From: Ross Leal
Sent: 22 November 2017 11:27
To: Planning.Responses
Subject: FW: AB/124/17/DOC

I recommend that Condition 3 AB/124/17/DOC be discharged.

AB/124/17/DOC

Proposed alteration to garage door, 34 Tarrant St.

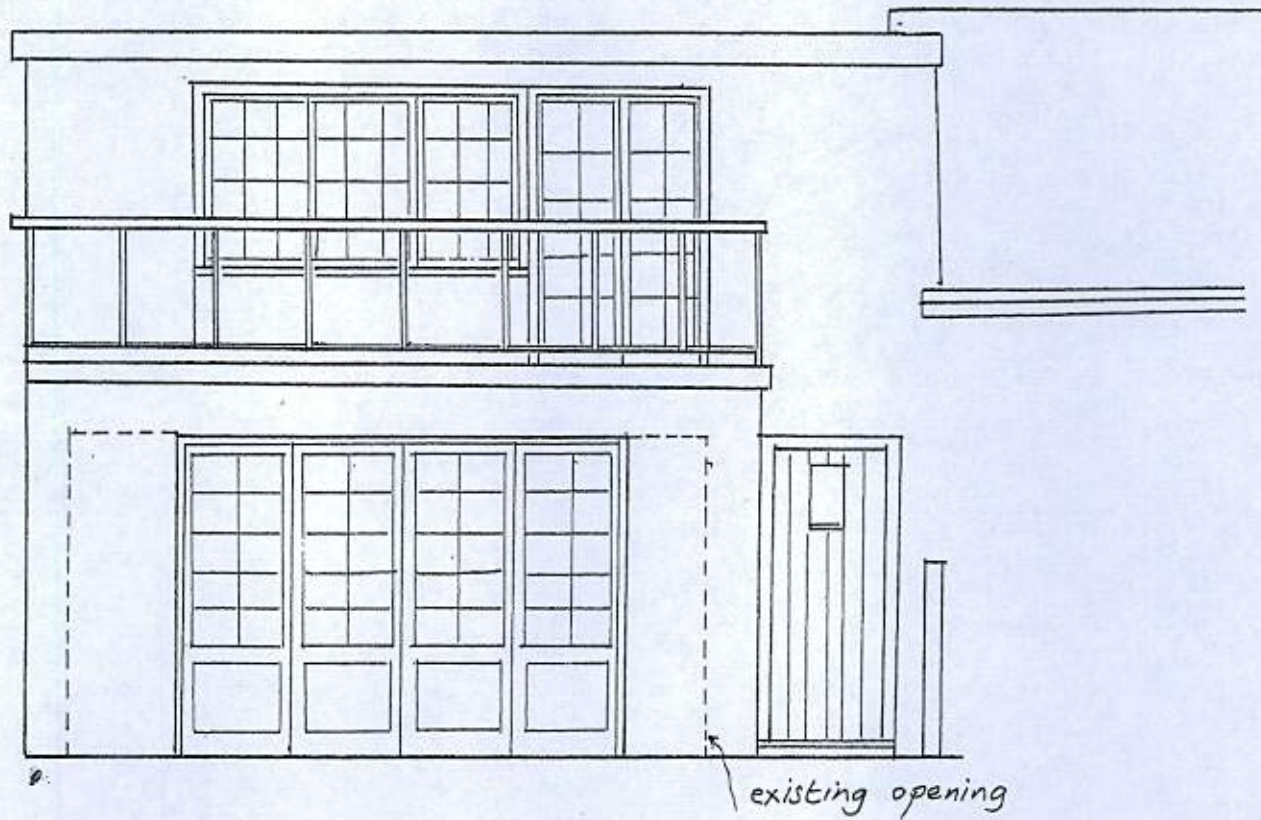
I can confirm that the joinery details as supplied are considered suitable to discharge Condition 3 of The location of the development is as 1980's extension to a listed property, and therefore Slim lite (or similar), double glazing, within traditional joinery as per the supplied drawing is considered acceptable in this location, and due to the area of glass being installed.

The supplied brick sample 'Atherstone' is considered suitable, with weatherstruck pointing.

**The aperture will be reduced by brickwork to either side.
This with a soldier course to replace the wooden fascia above what is now an up and over garage door.**

**Details of the bond to be used for the new brickwork are:
Original brickwork to be toothed out and new brickwork to be built in stretcher bond to
match existing, as will the pointing either struck or weather pointed.**

**Regarding the new doors, details of the type of unit proposed are:
White painted wood, eggshell finish configured as in the application drawing, with individual panes of thin double glaze
within timber glazing bars. As per attached drawing and specification document from The Wright Joinery Company Ltd.**
